EL PASO COUNTY PARKS DEPARTMENT | PARK PLANNING DIVISION

September 16, 2026

Subject: The Markets at Bent Grass -Preliminary Plan (SP-26-002)

PP-3
3 OF 12

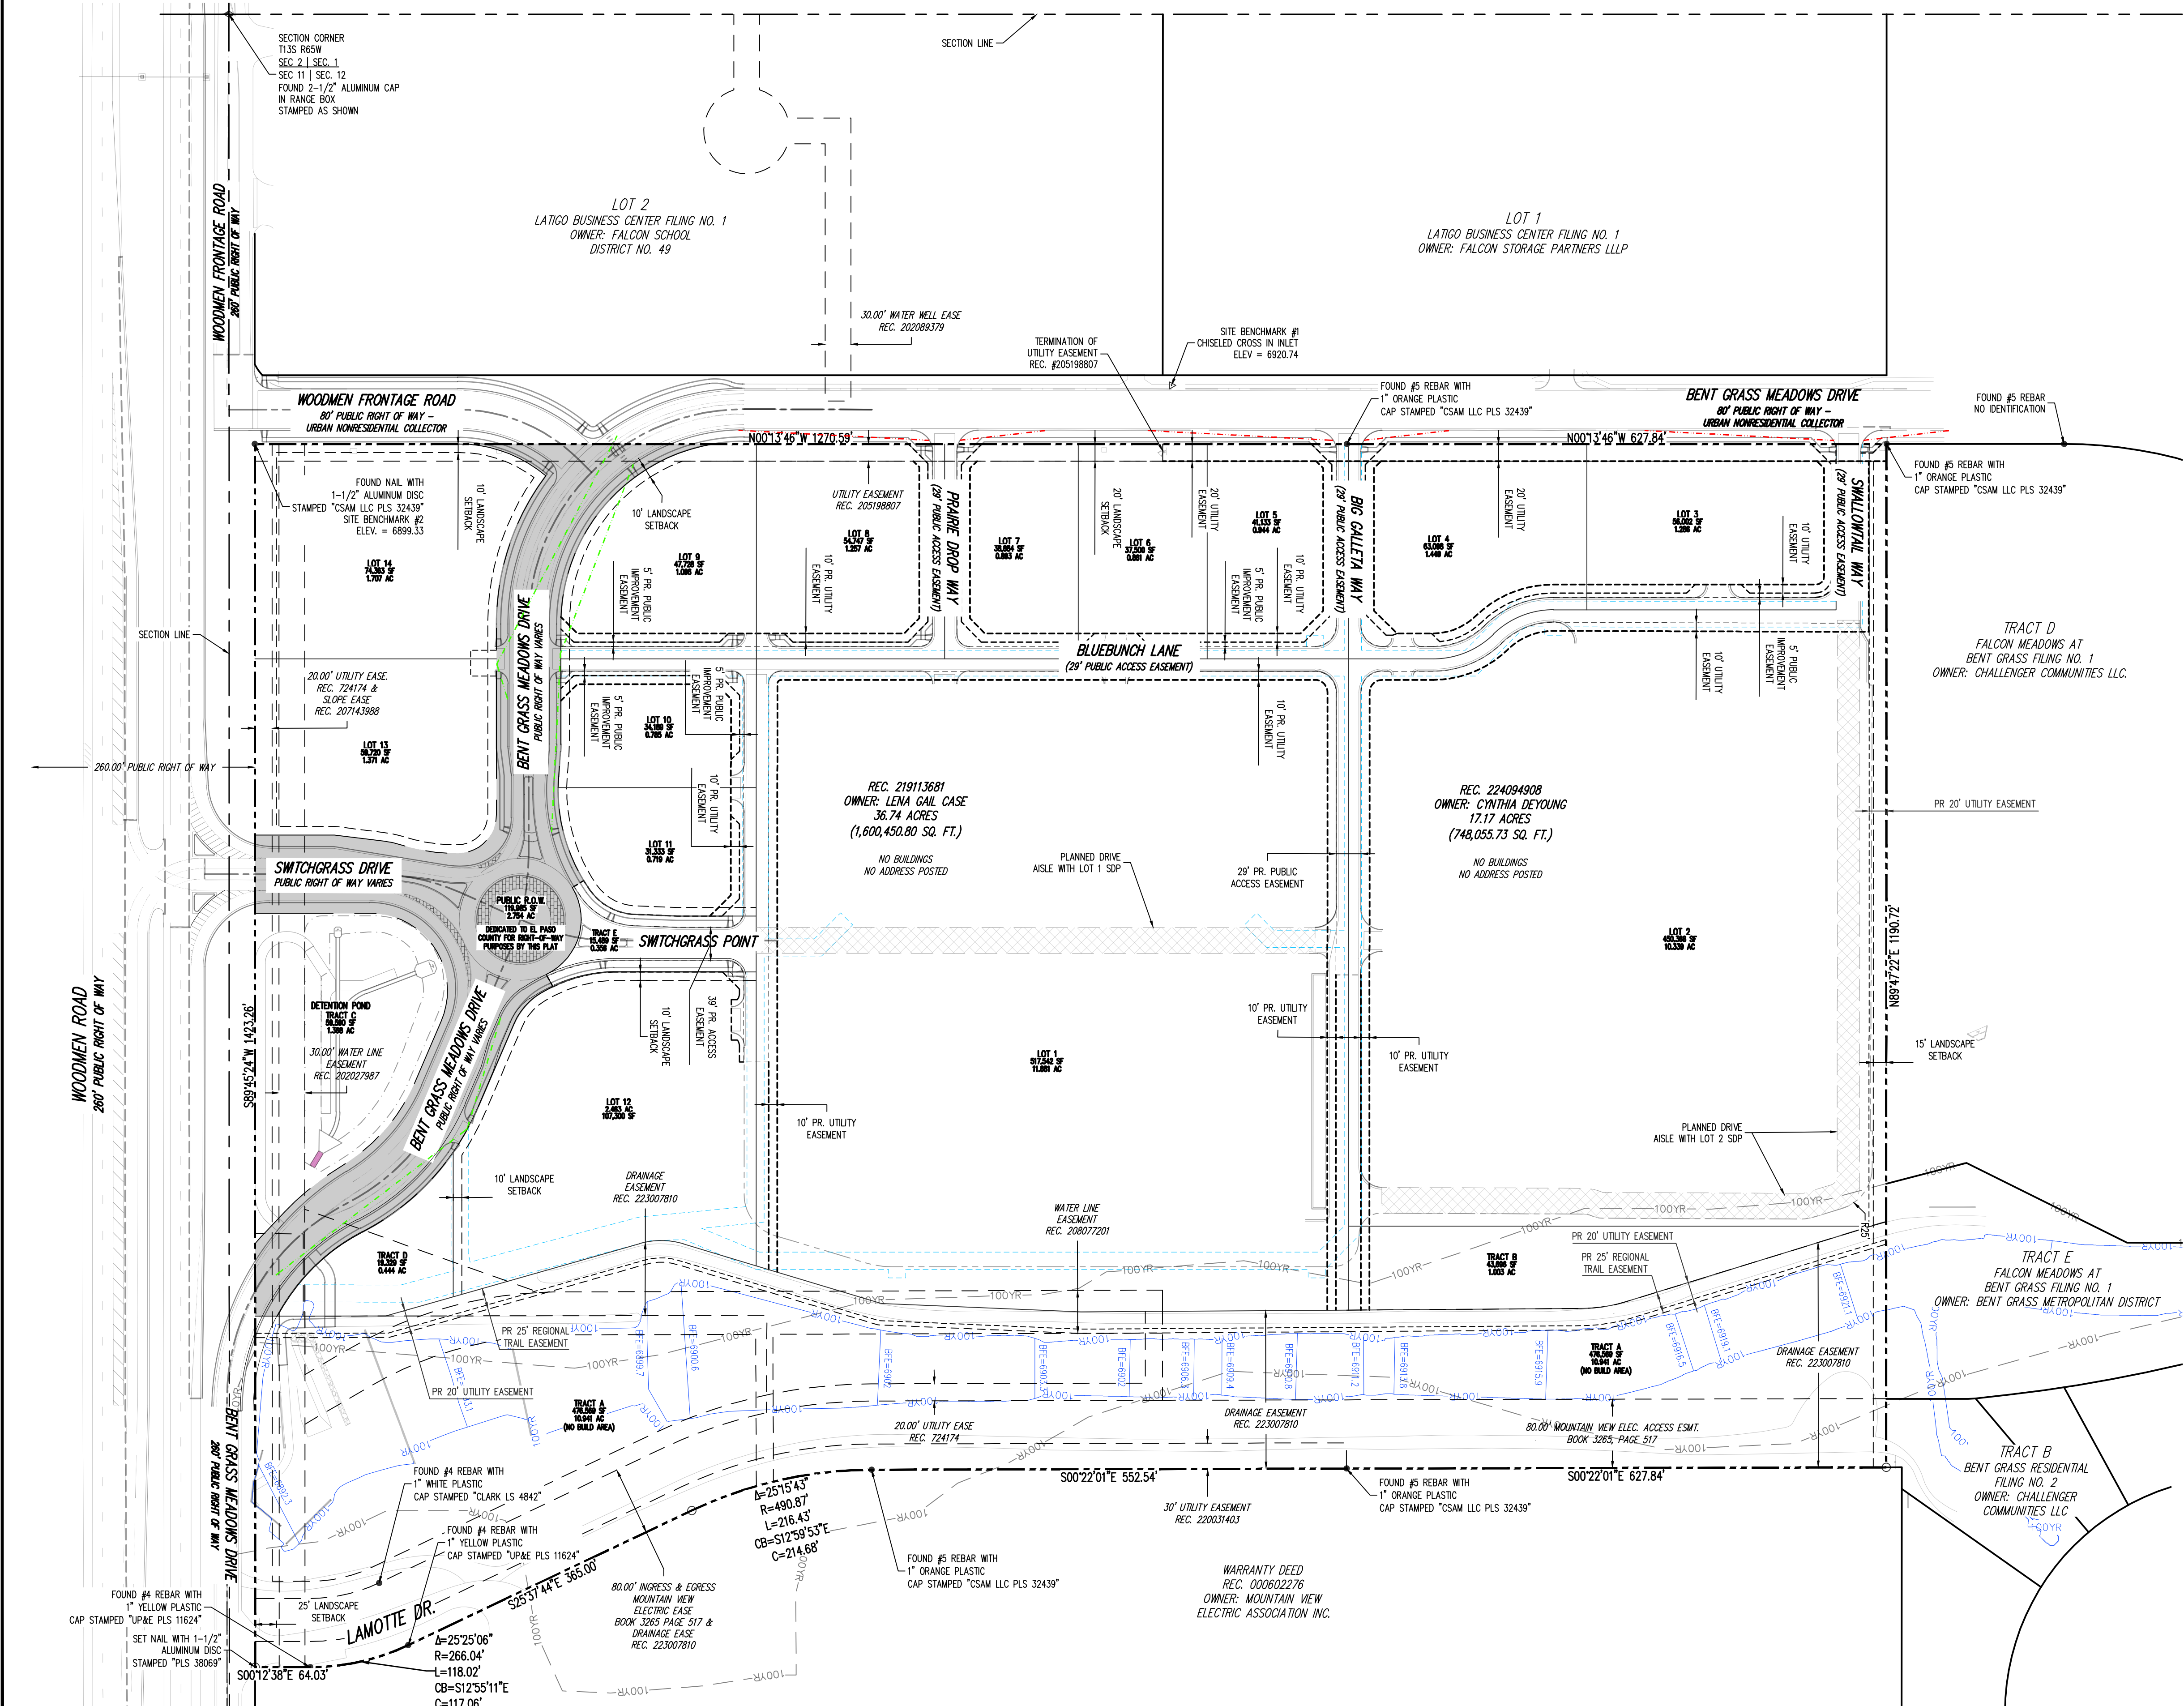
The preliminary plan currently depicts a 25' trail easement along the easterly drainage consistent with the El Paso County Parks Master Plan on page PP-3 Lot & Tract Plan. However, staff is still requesting that a plat note identifying the trail easement to El Paso County be included at both the preliminary plan and final plat stages.

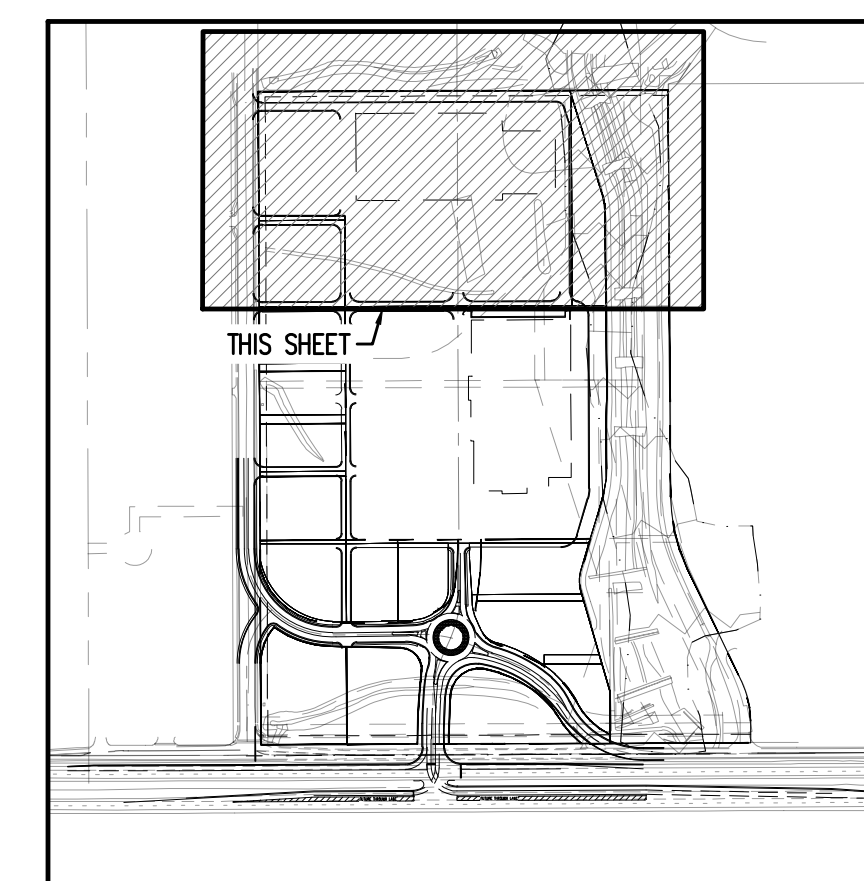
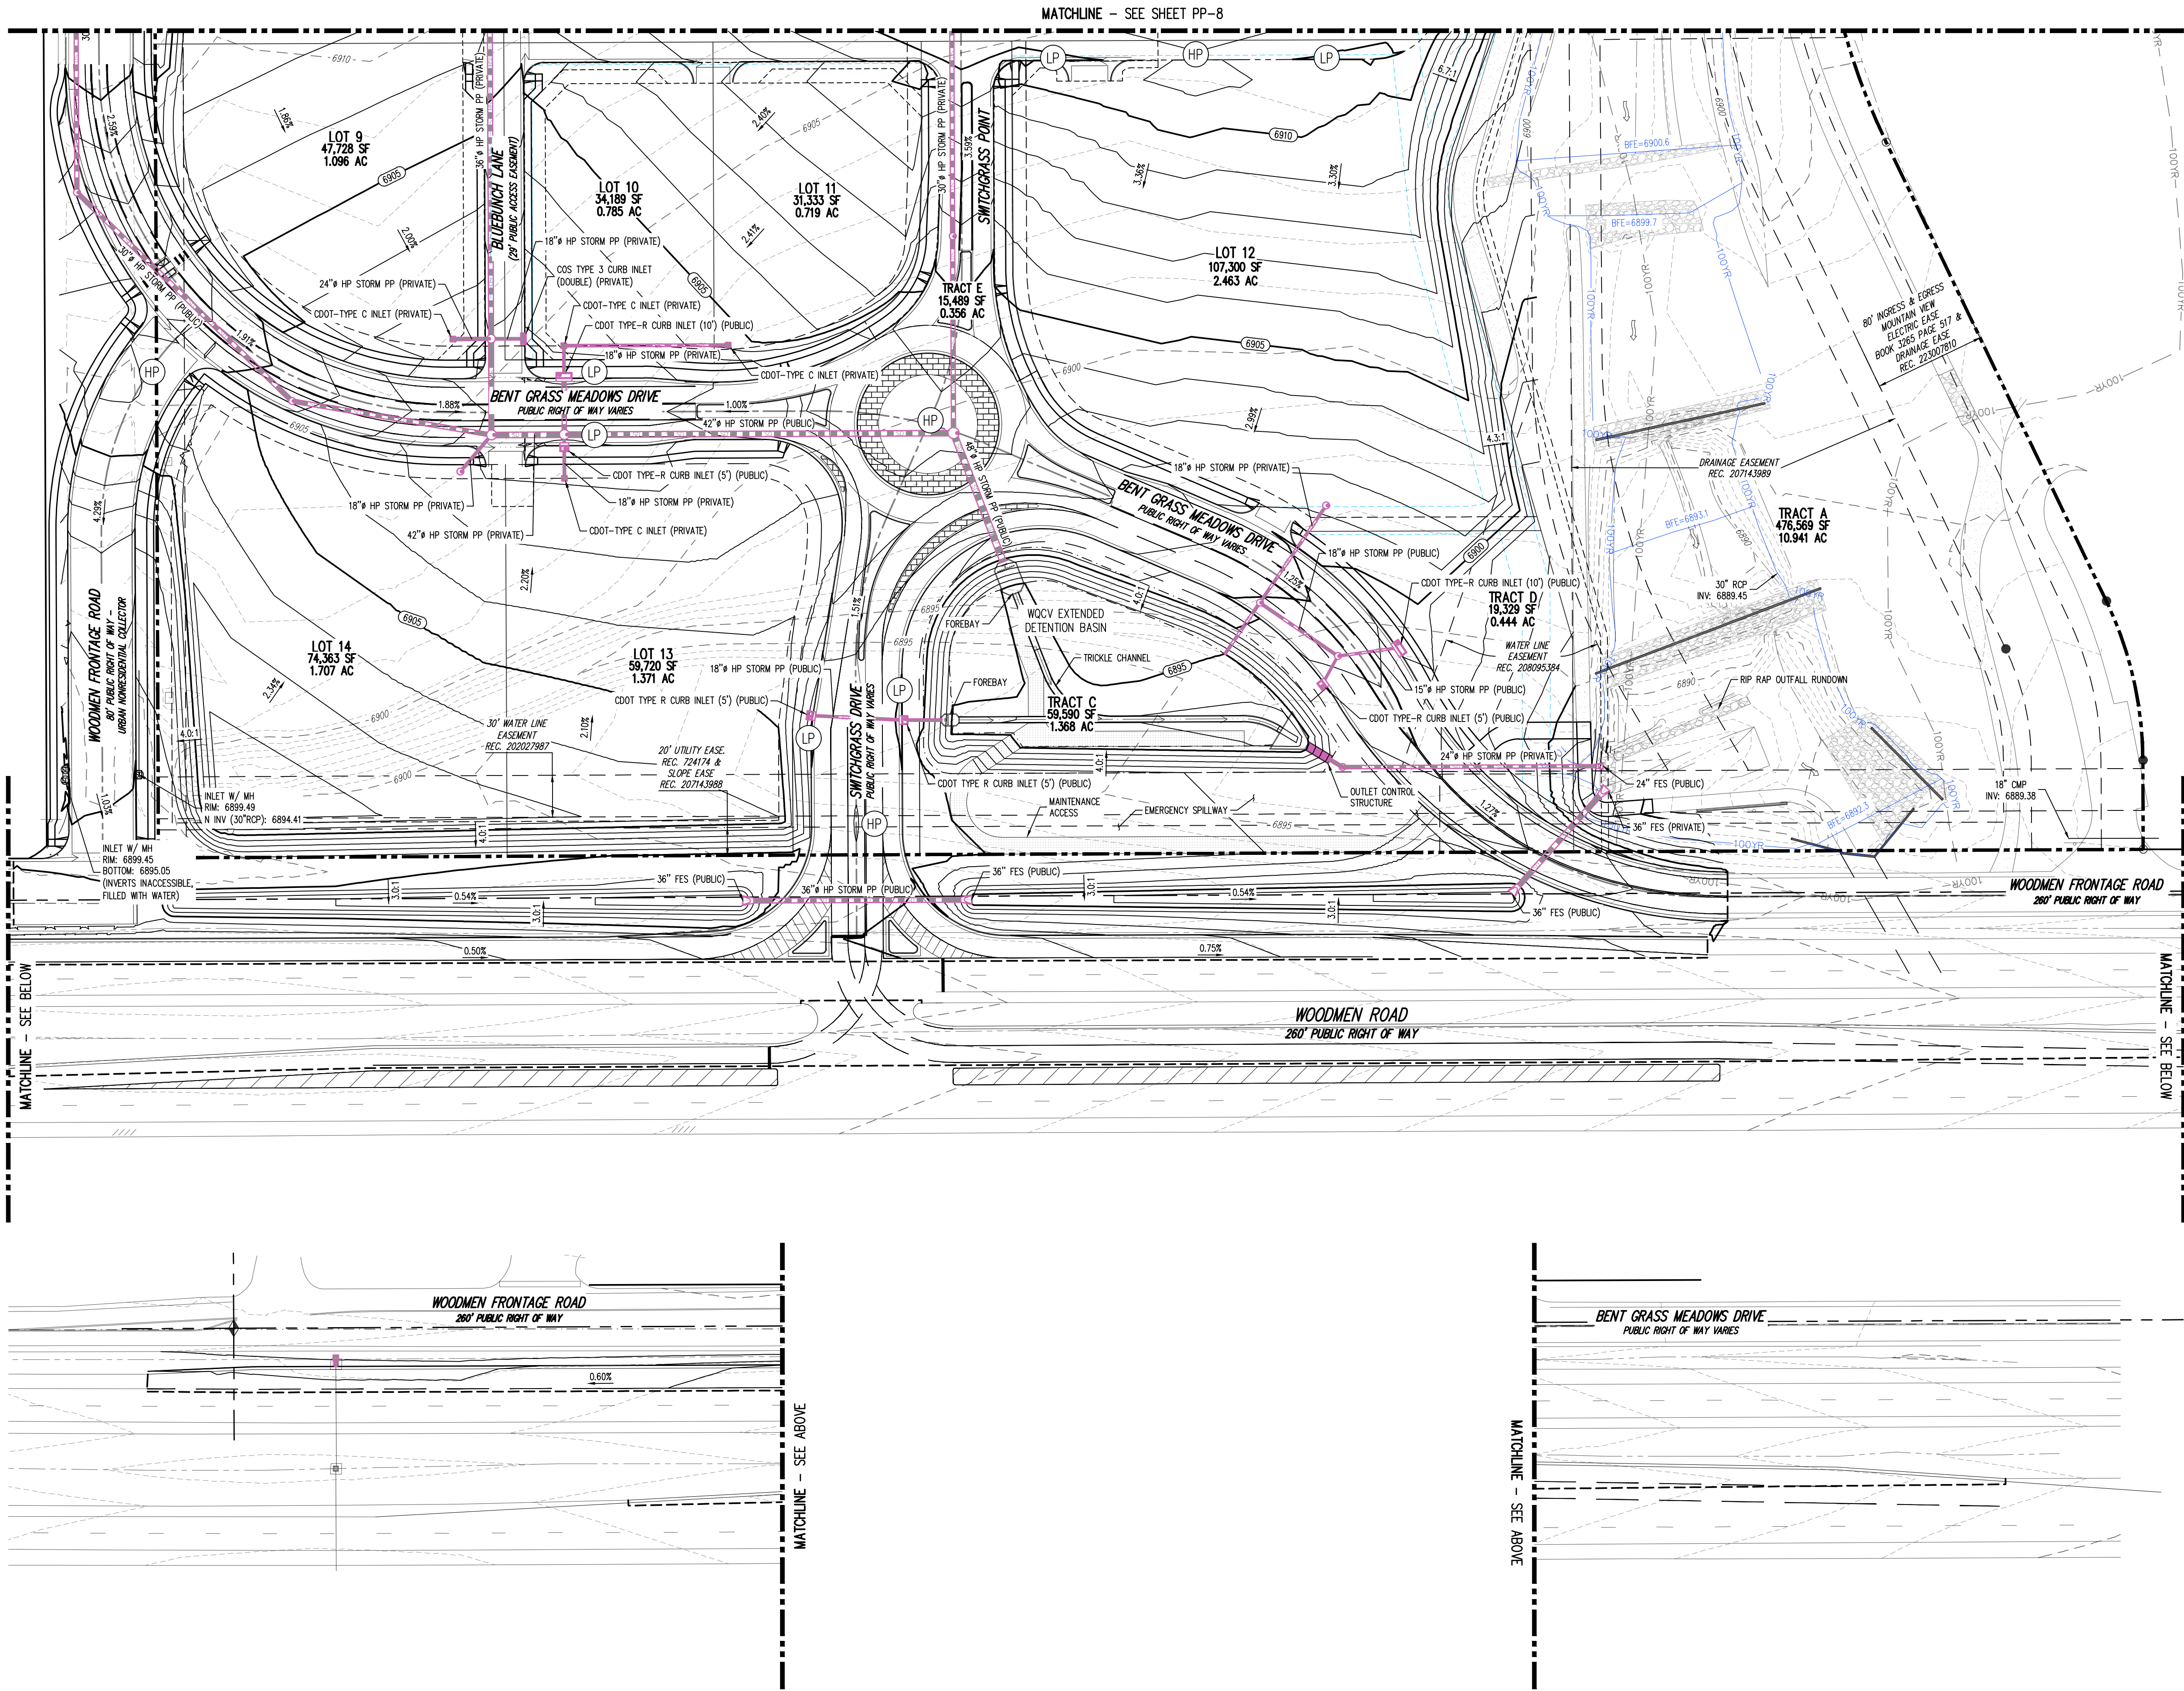
As previously mentioned, a portion of the Woodmen Hills Secondary Regional Trail exists along the Easterly drainage corridor that both connects to Woodmen Road and traverses underneath via a concrete box culvert. Staff has reviewed the project and notes that the applicant is depicting the trail connection and that this is being shown on the grading plans as staff have previously requested.
